KITTTITAS COUNTY DEPARTMENT OF PUBLIC WORKS

MEMORANDUM

TO: Community Development Services
FROM: Christina Wollman, Planner II *CW*
DATE: October 22, 2009
SUBJECT: Elita Short Plat SP-08-00041

**K.C.S.P. NO. 08-XX**  
PTN. SE 1/4 OF SEC. 9, TWN. 19N., RGE. 15E., W.M.  
Kittitas County, Washington

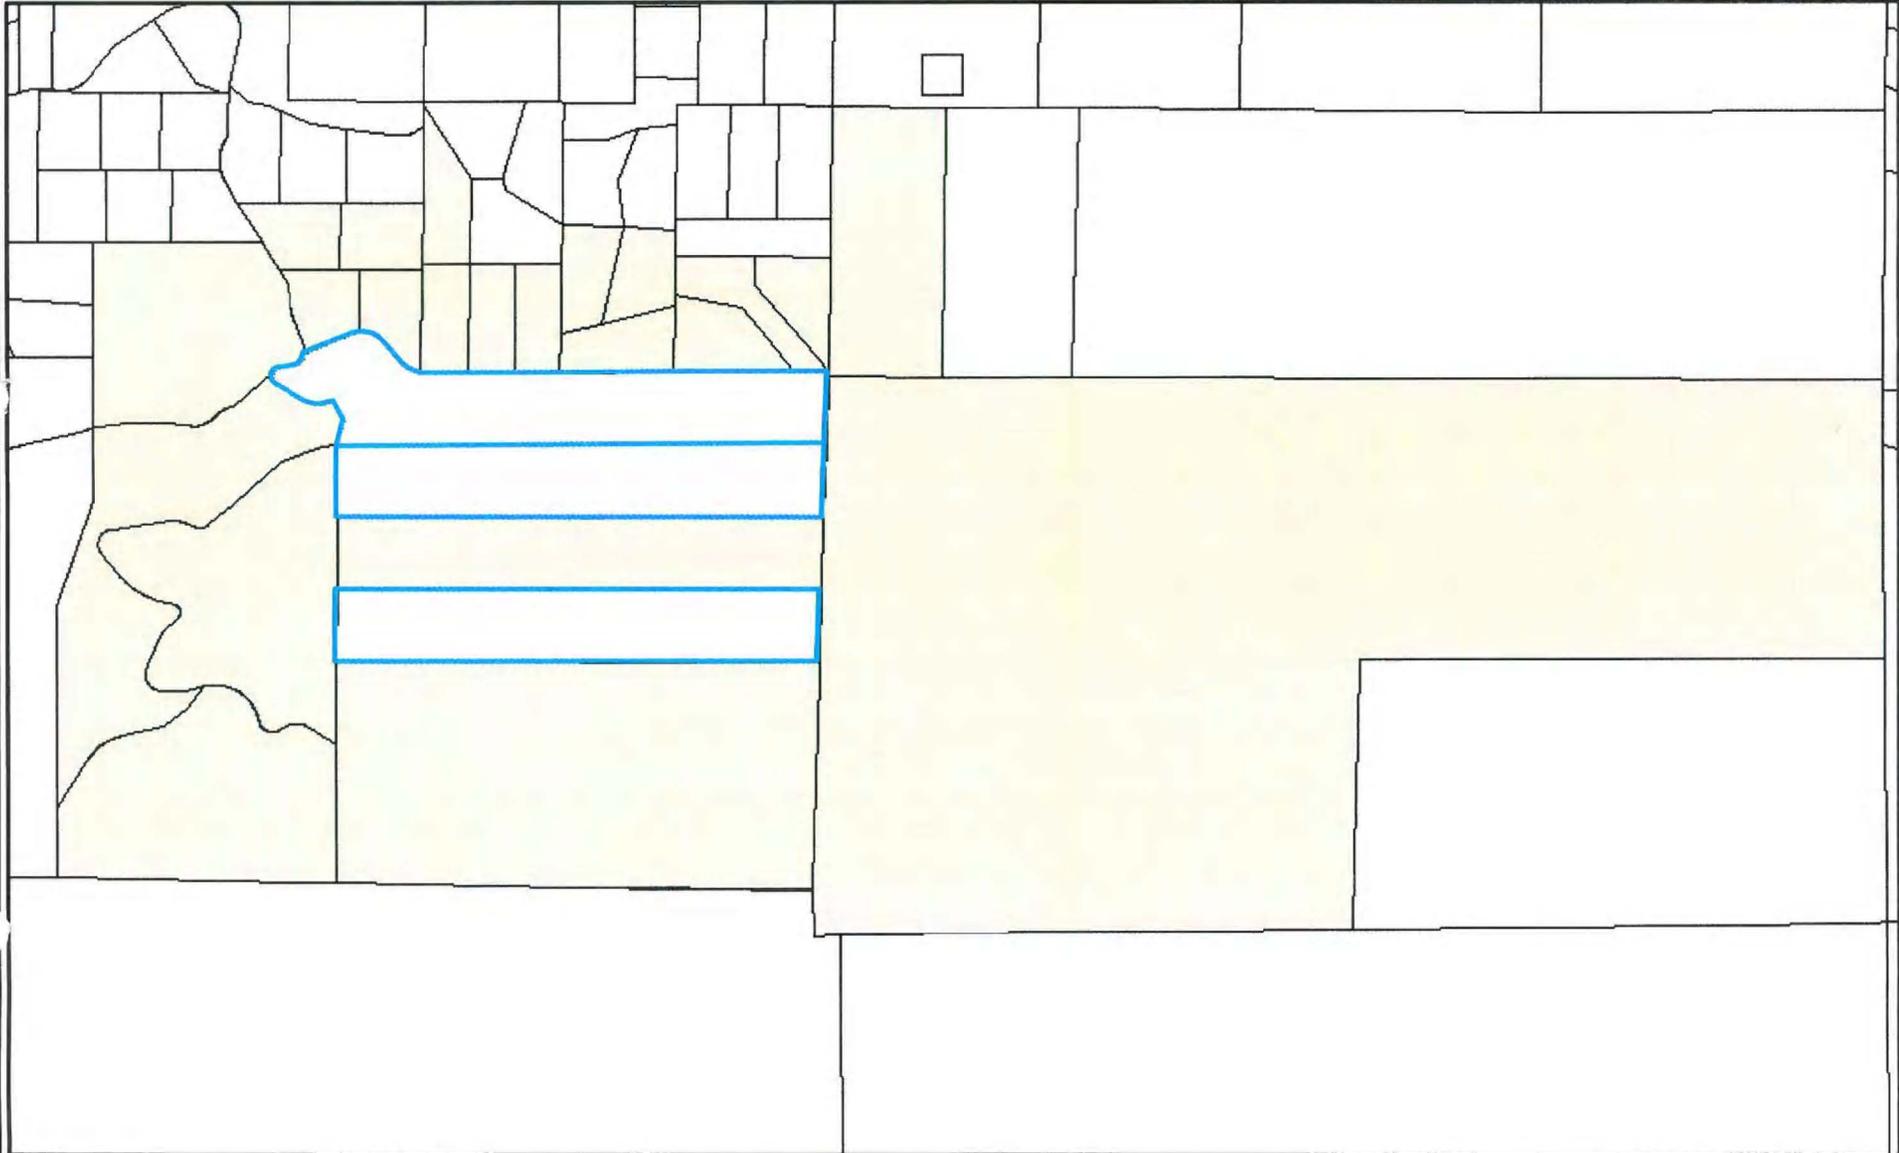
3. Second Access: The second access route shall be shown on the final plat or within the vicinity map.
 4. Improvements to South Cle Elum Ridge Road and Rocky Mountain Road: From Westside Road to the entrance to the Plat, access roads shall be constructed as High Density Roads that serve 40+ lots.

5. Cul-de-Sac: A cul-de-sac turn-around having an outside right-of-way or easement diameter of at least 110 feet shall be constructed at the end of Rocky Mountain Road. The driving surface shall be at least 96 feet in diameter. Cul-de-sacs must also conform to the requirements specified by the 2006 International Fire Code. Contact the Fire Marshal regarding any additional cul-de-sac requirements.
